**Consultation Response from Alan Smith,
KC Waste Strategy (Refuse & Recycling)**

2026/90441 Huddersfield Bus Station, Upperhead Row, Huddersfield, HD1 2JN

Discharge of details reserved by conditions 11 (bins), 15 (BEMP), 22 (Phase II Intrusive Site Investigation Report) on previous permission 2025/91604 for variation condition 2 (plans) on previous permission 2024/92302 for refurbishment comprising (phase 1): facade improvements including Henry Street entrance; replacement shop fronts; alterations to external bus apron; extension and alterations to existing barrier within the bus alighting lane adjacent to Henry Street; (phase 2): new entrance canopy; public realm improvements; cycle hub; facade improvements including replacement shop fronts

Responding Ref: WPS 26 009

P2 Proposed Bin Store Plan  
Scale: 1 : 50

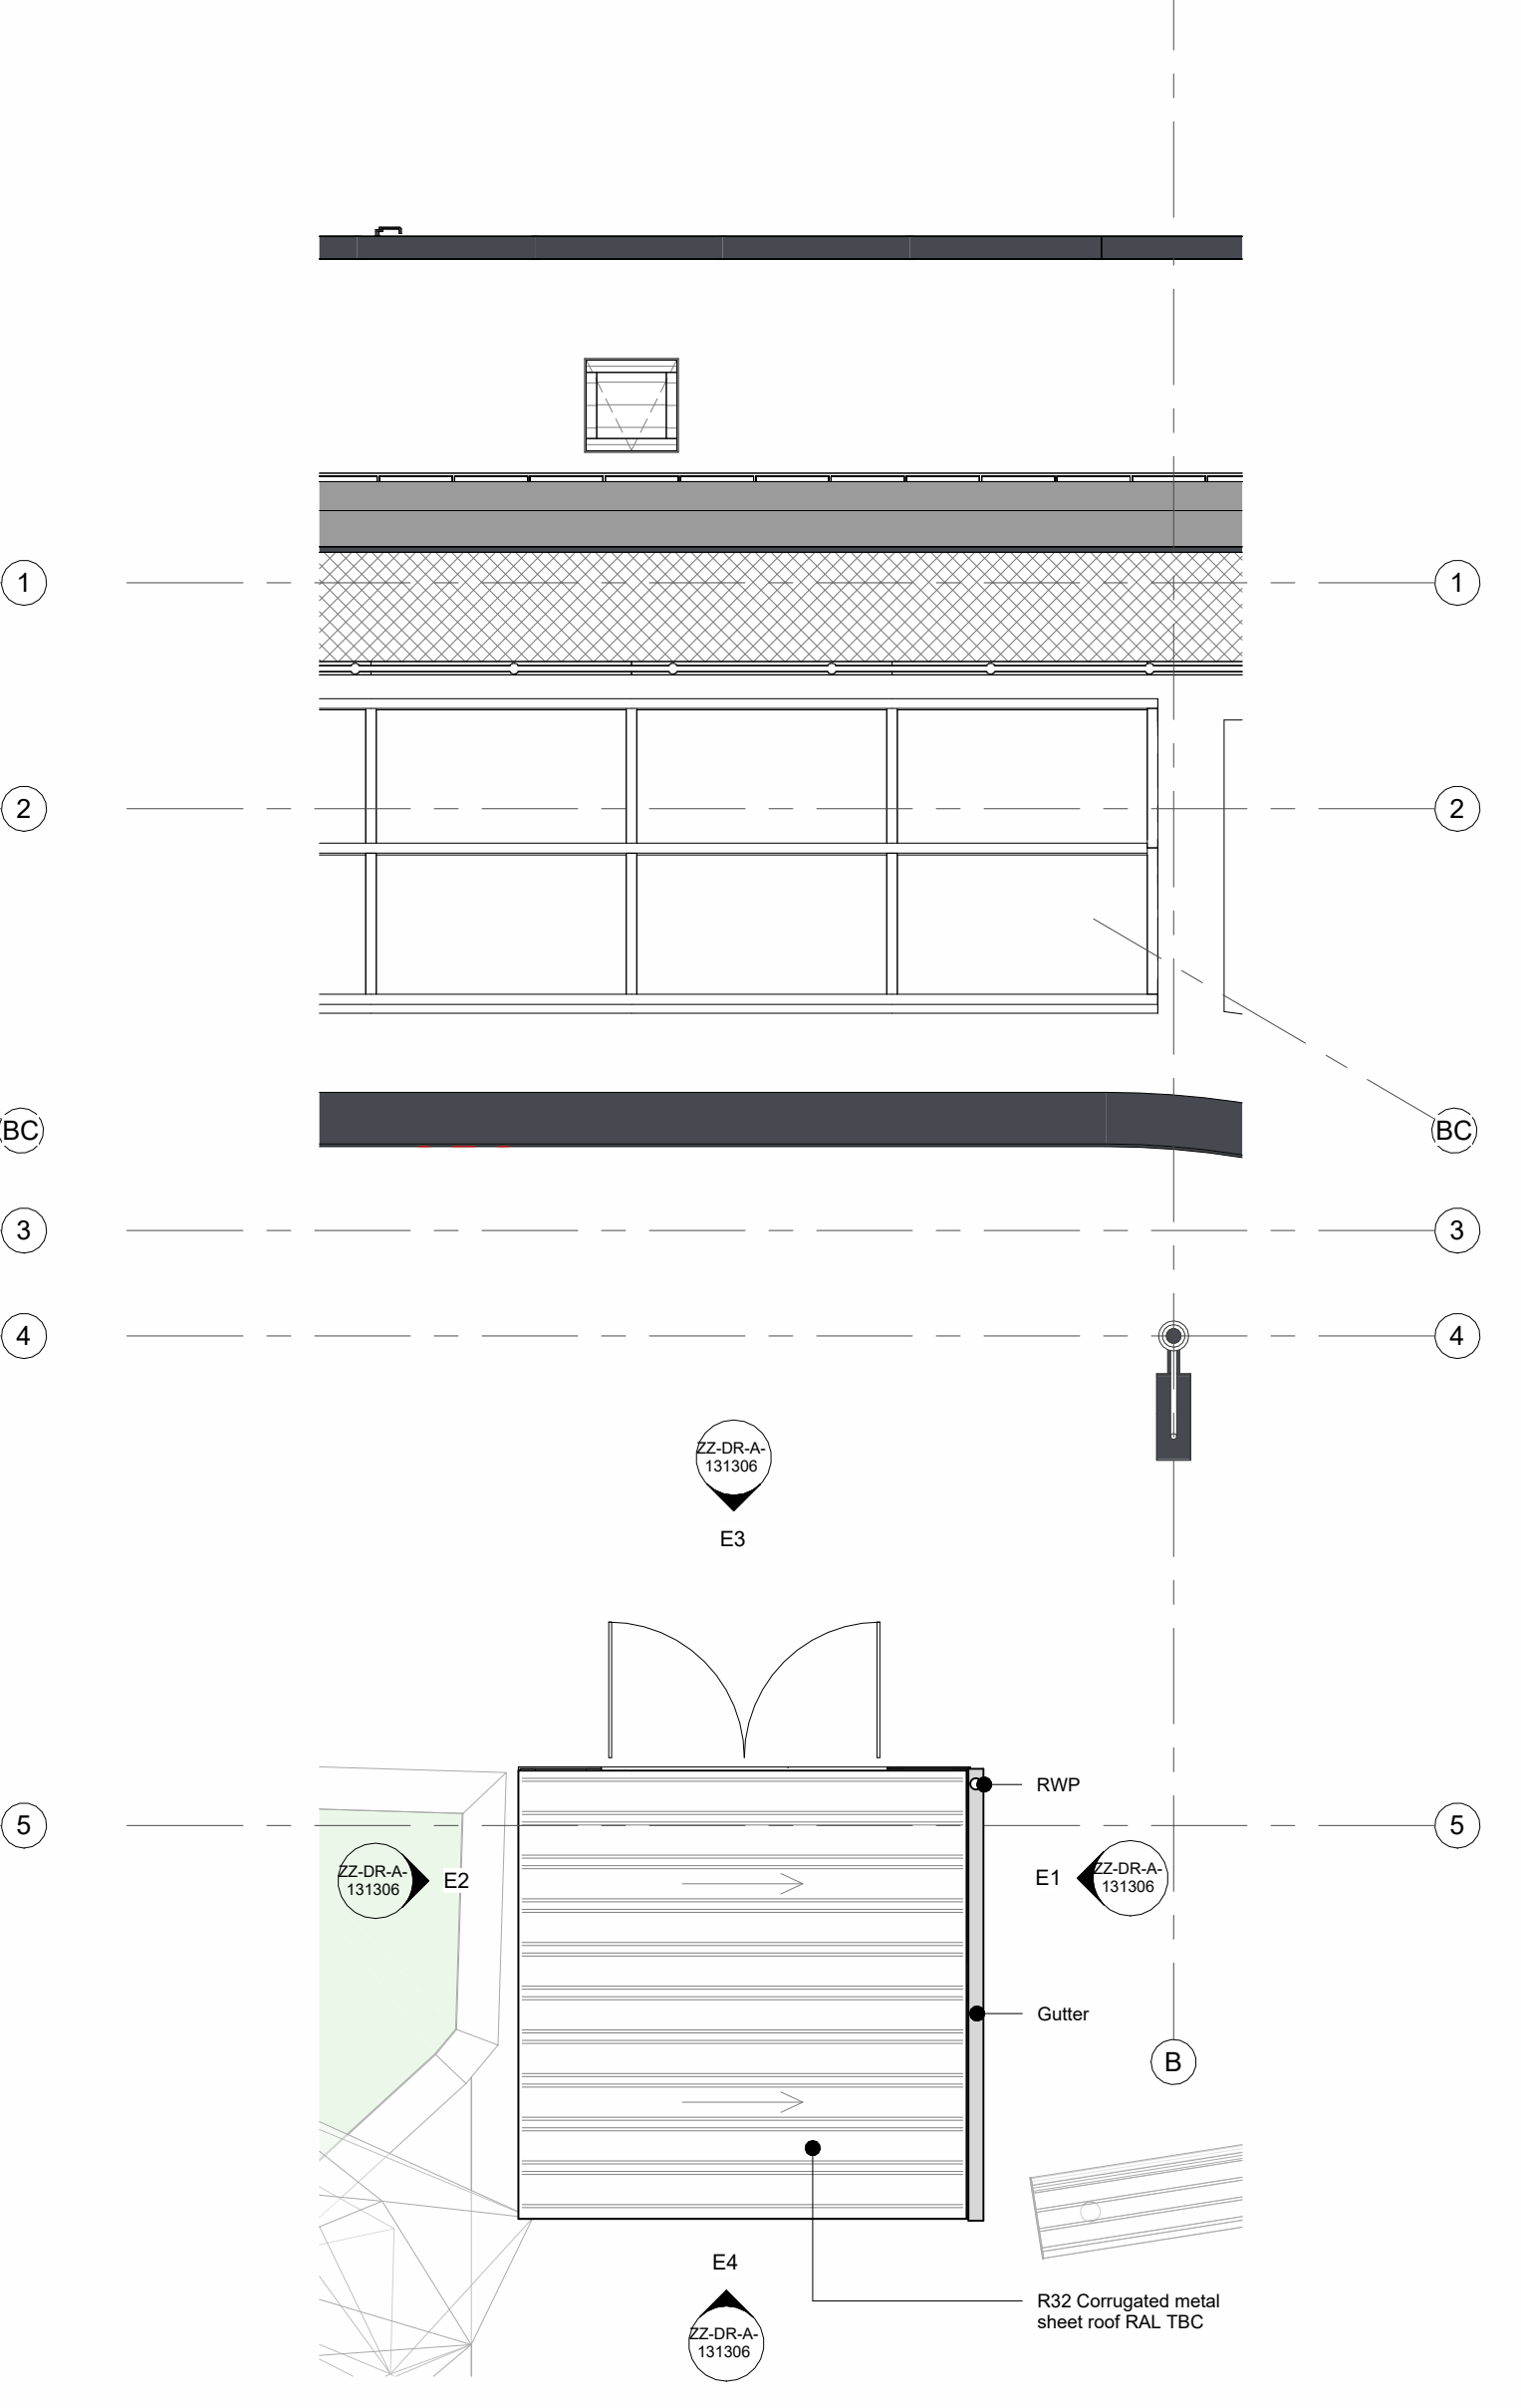
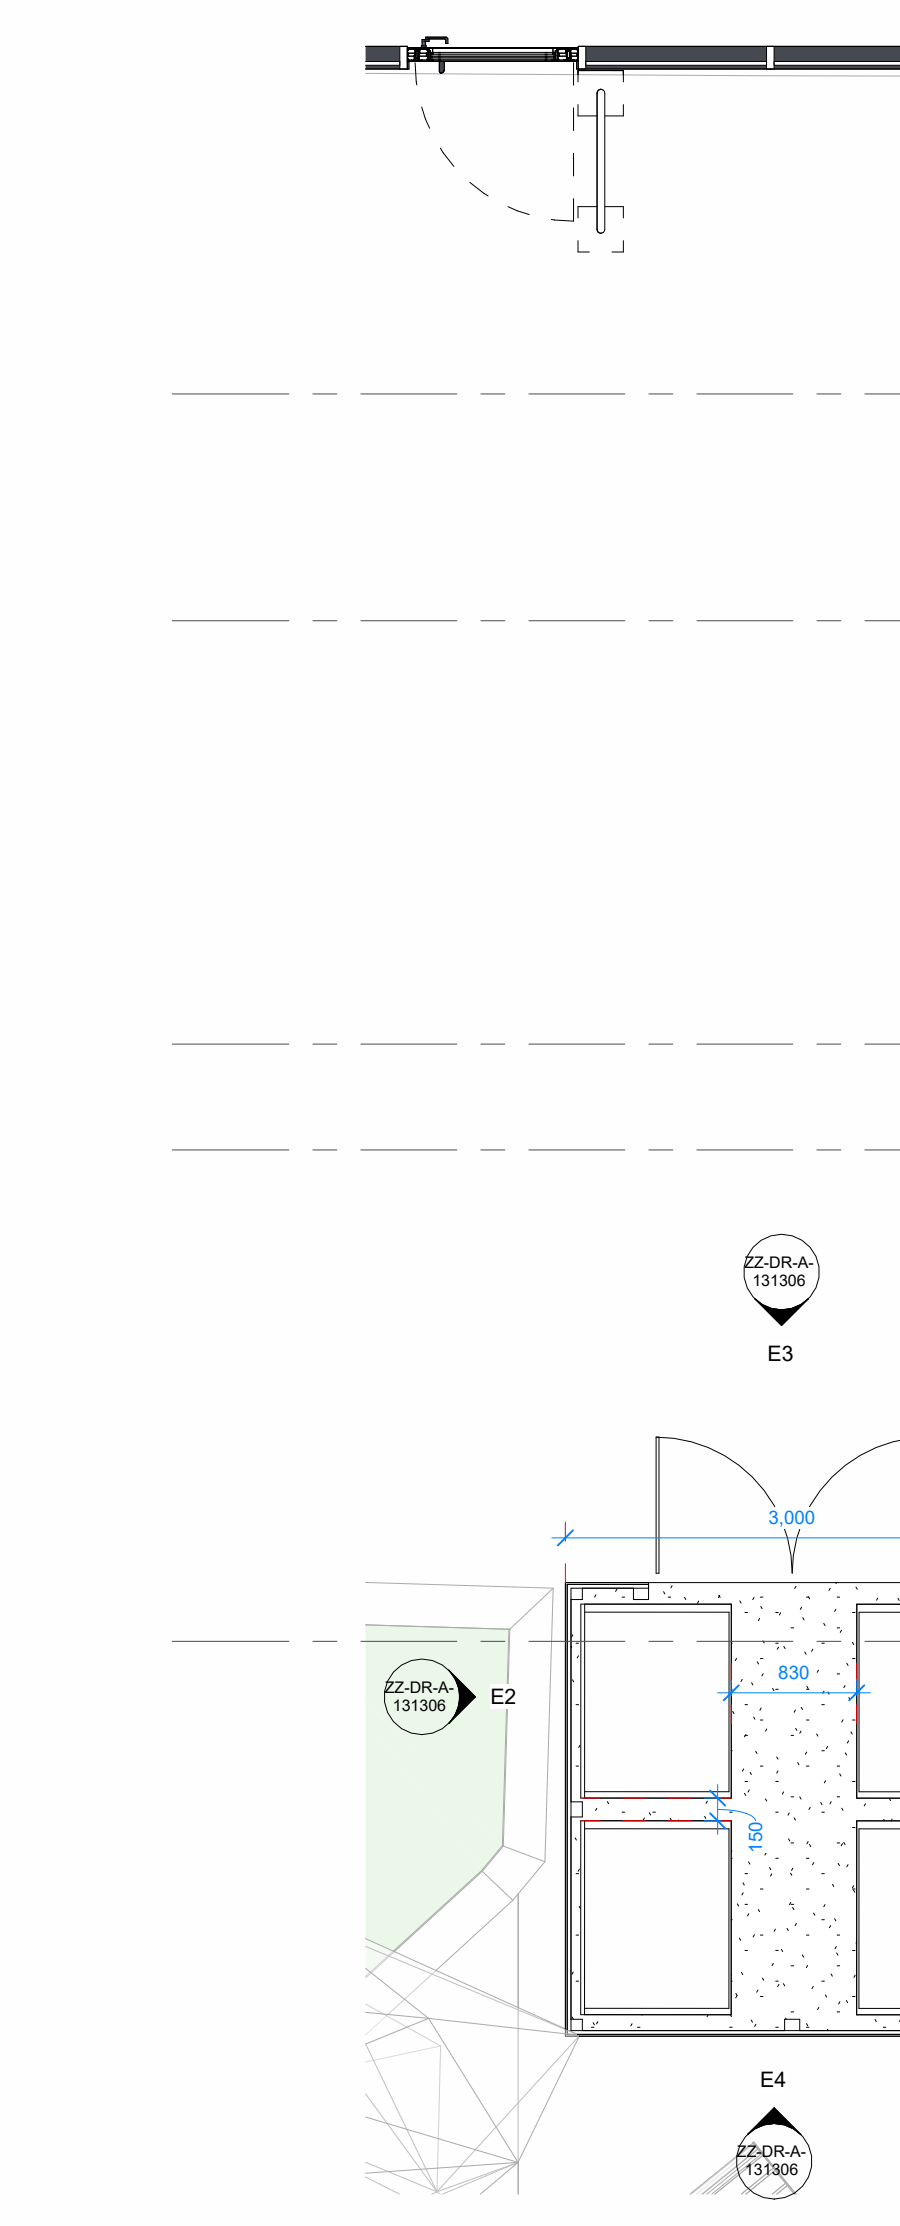
The bin store only shows room for 4 bins, this is too small and needs to be larger to be able to accommodate 8 bins that are currently on the site. Given the information provided by the developer the WCA cannot agree to the Discharge of Condition 11 for the site until the bin store is made larger.
